# PHOENIX FIRE PROTECTION

Date: November 11, 2025

Re: Wet Pipe Sprinkler Systems  
Comments Addressed Ref. Optima # 24-0049R  
HCS Flatwoods Middle School  
3544 US 401 South  
Lillington, NC

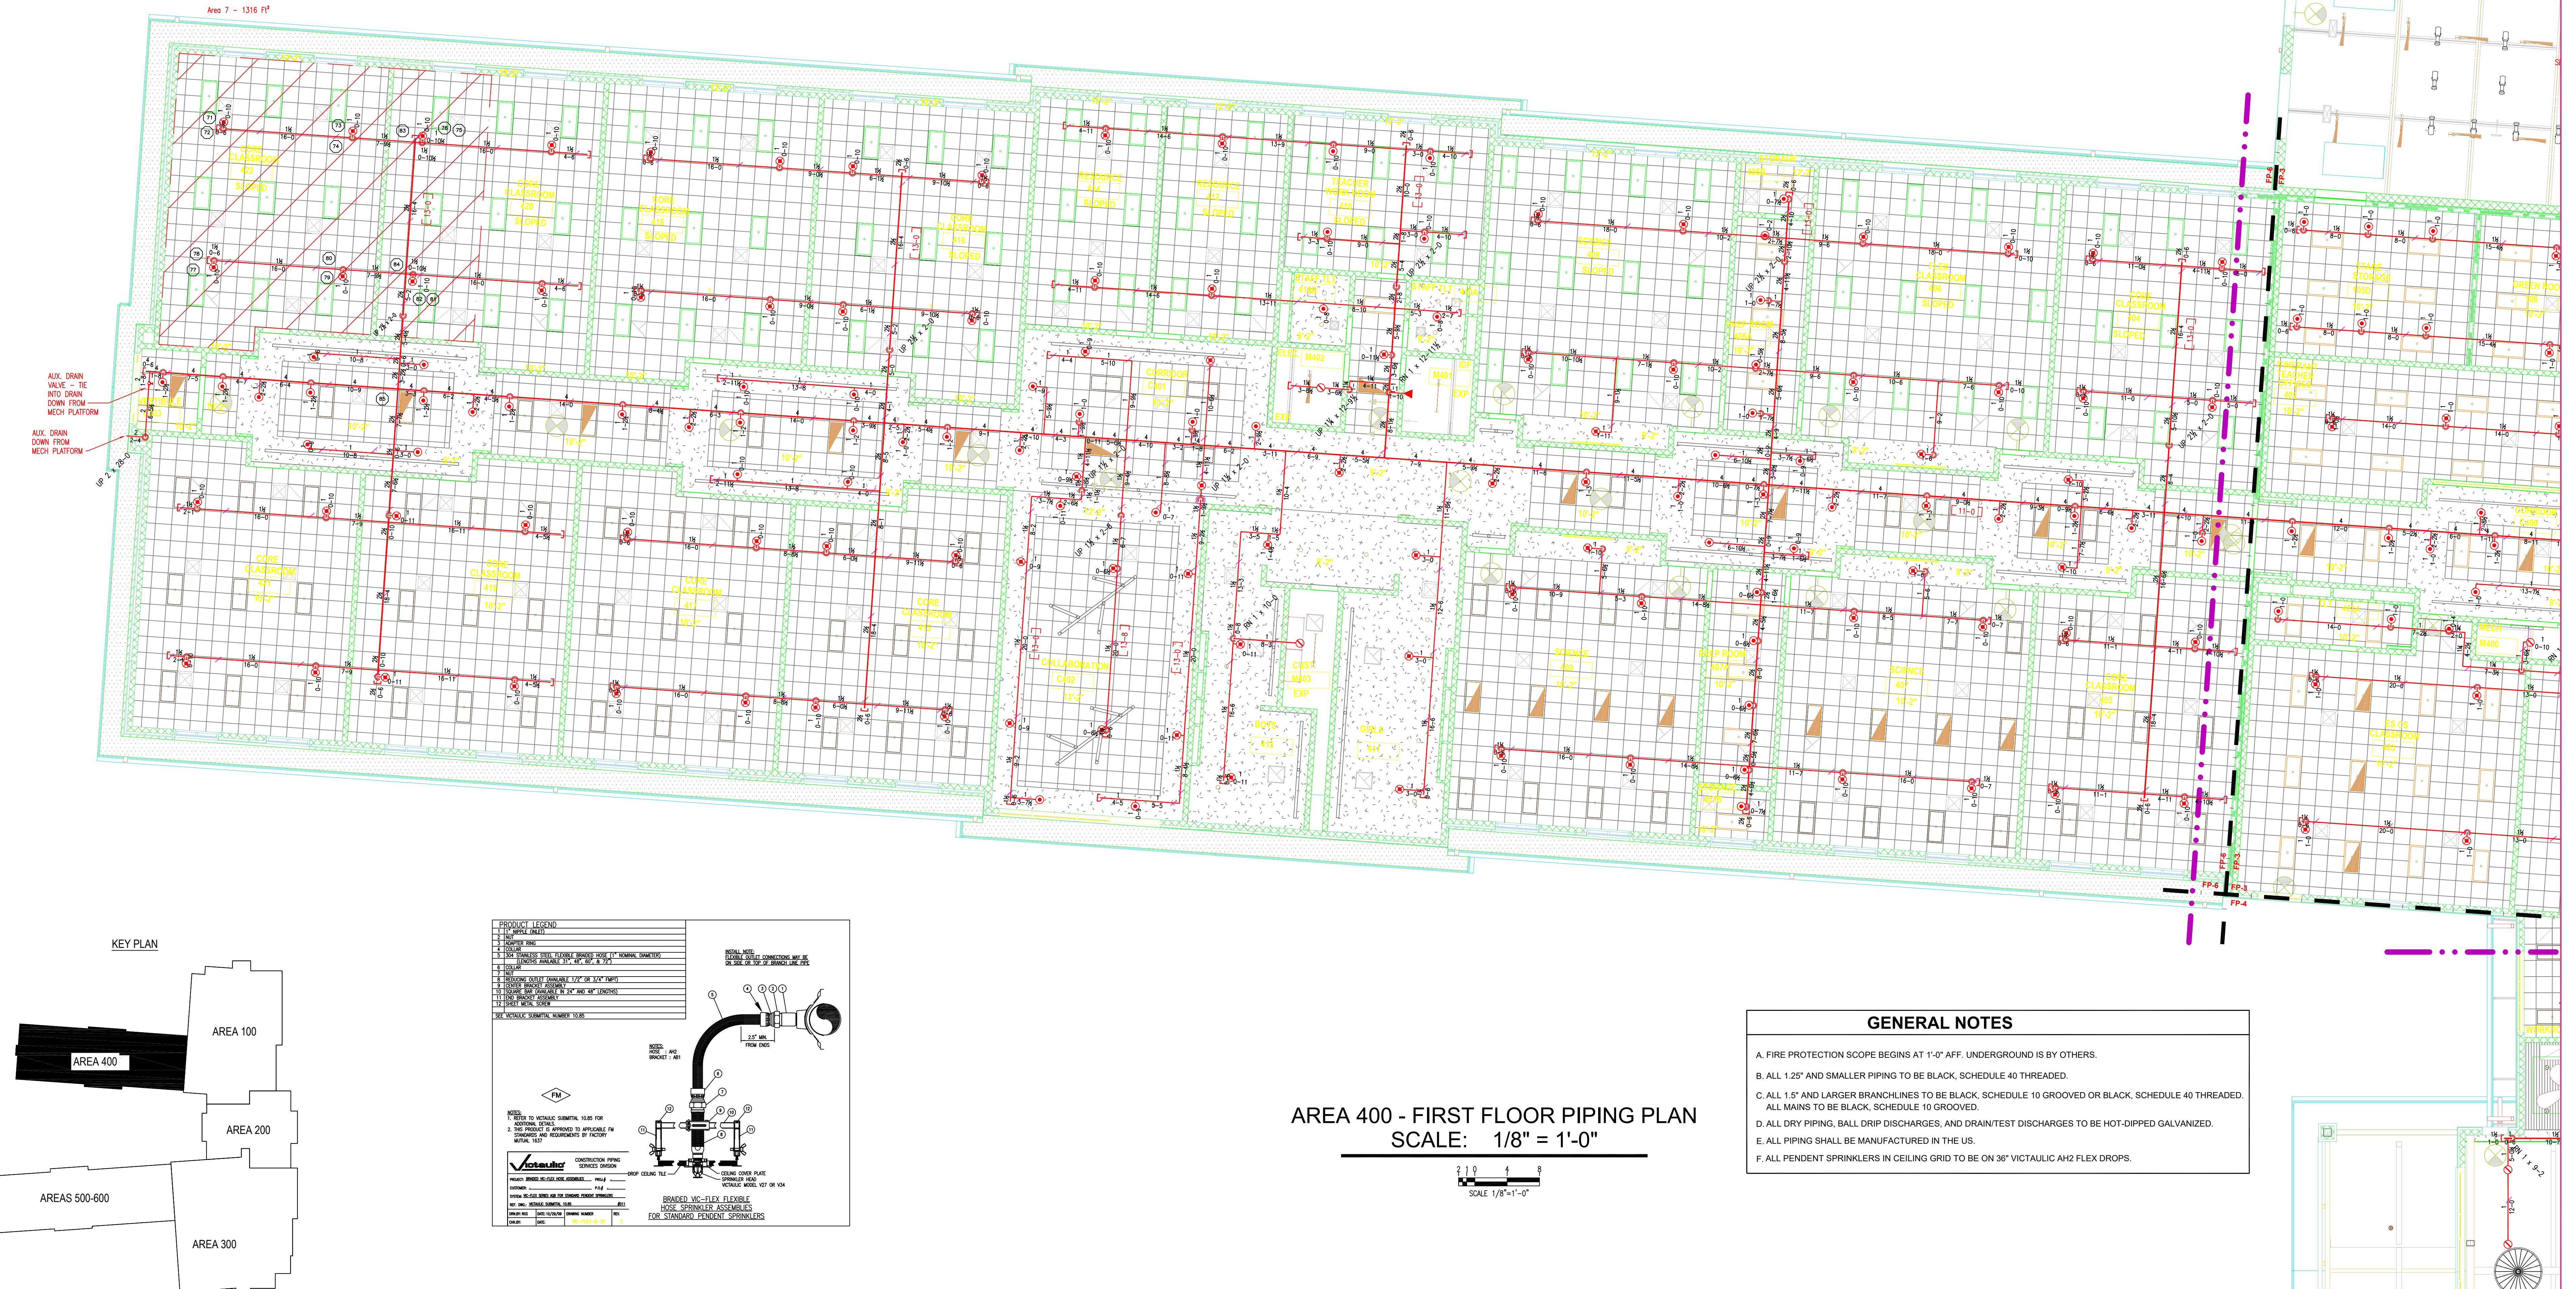
- Branch line has been relocated to run south and then pass through bulkhead
- The sprinkler shown outside of Lobby has been removed, it is not required.
- A 4-inch fire main has been added running down the East wall with the branch lines running between beams.

AREA 500/600 - FIRST FLOOR PIPING PLAN
SCALE: 1/8" = 1'-0"

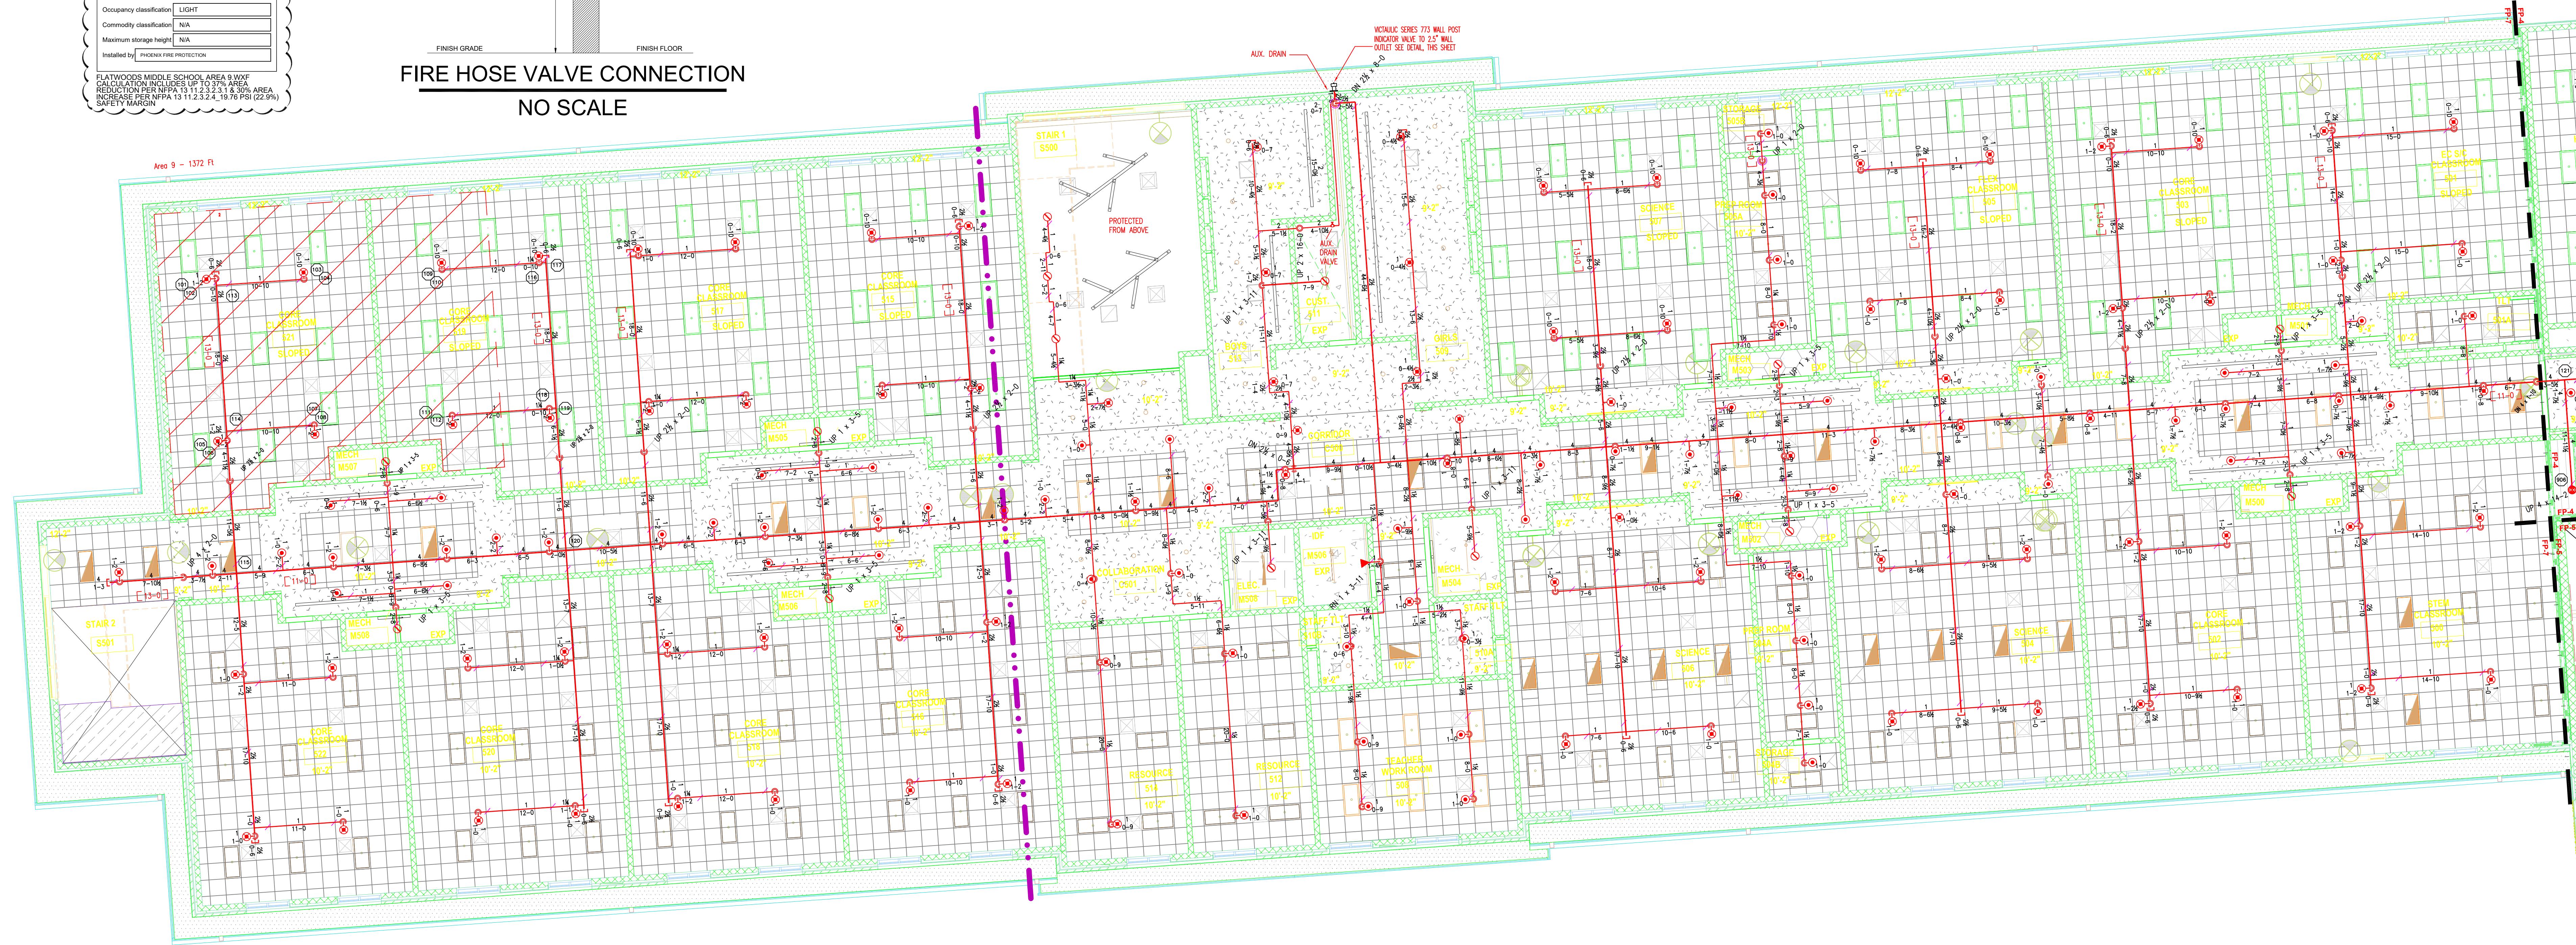
- Branch lines have been routed between beams.
- Sprinklers are not required under the covered porches / overhangs. The areas are non-combustible and not used for storage, pedestrian use only.
- The fire main in Dining 300 has been relocated.

AREA 100 - SECOND FLOOR PIPING PLAN
SCALE: 1/8" = 1'-0"

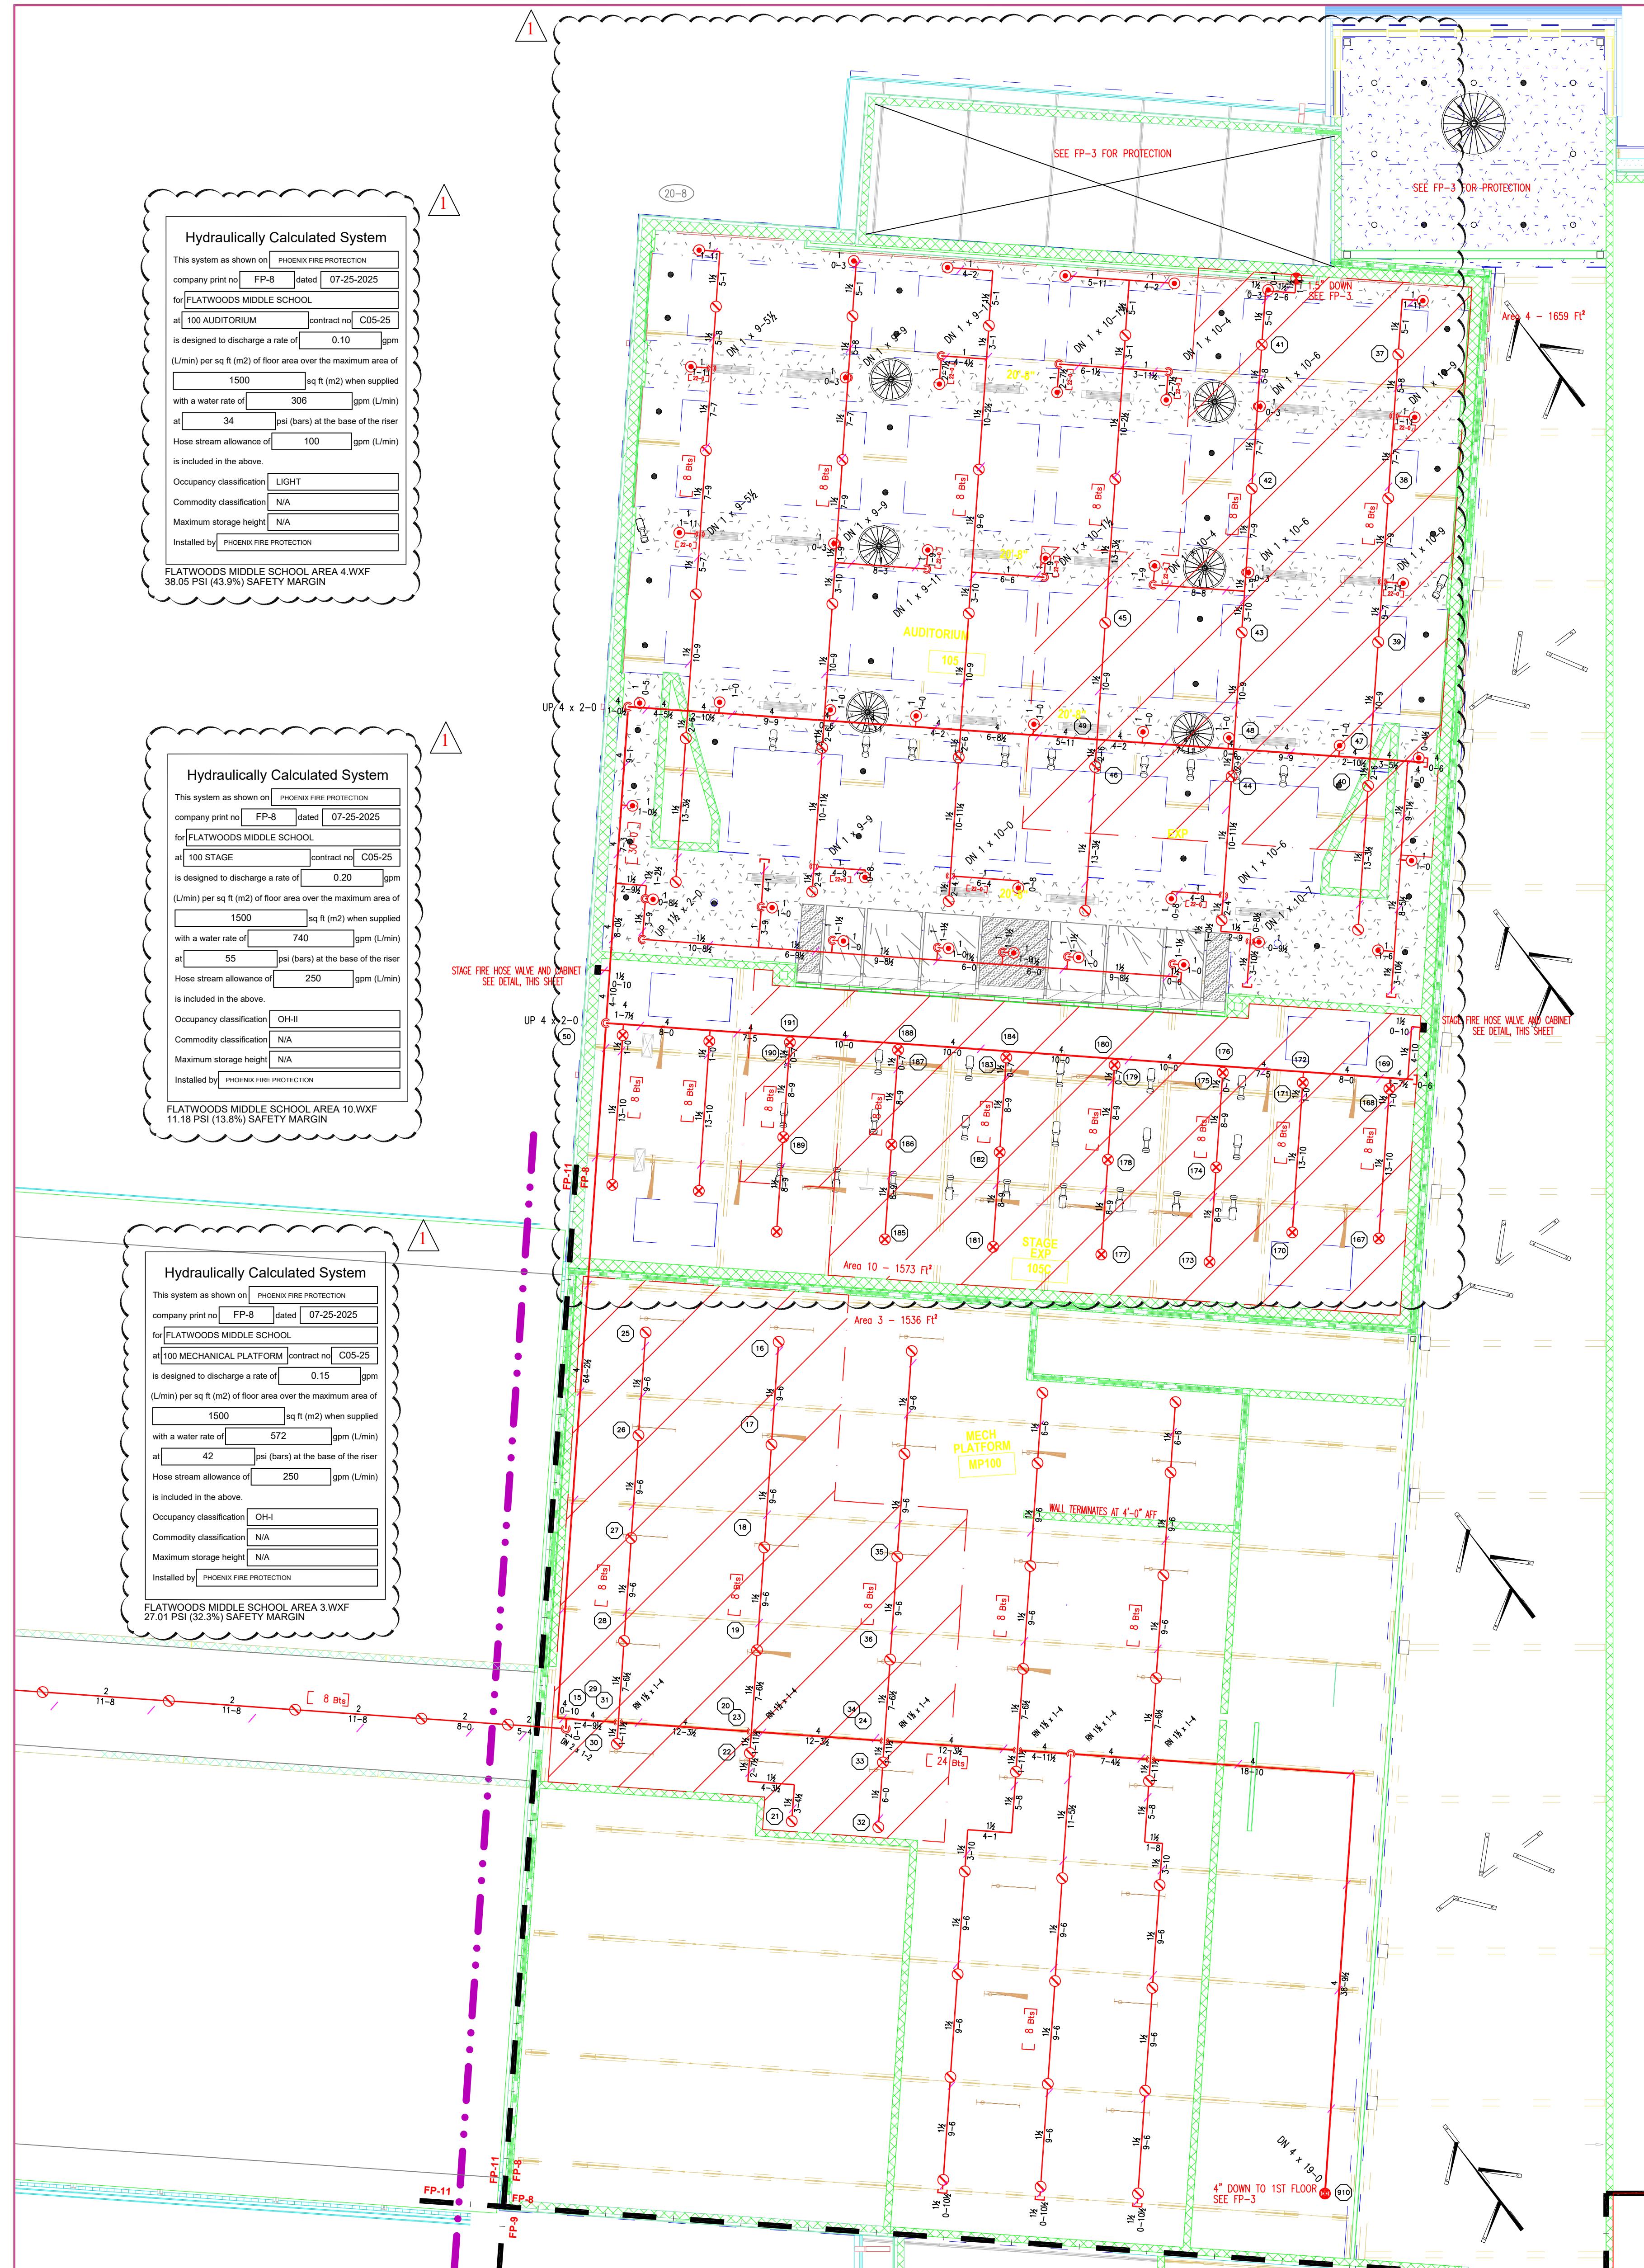
- Sprinkler line will be running down metal stud furr out as requested.
- Sprinklers cannot be placed between acoustic panels. The spacing would be too far apart and too far from deck above.
- Additional sprinklers to be added below ceiling bulkhead along north wall.
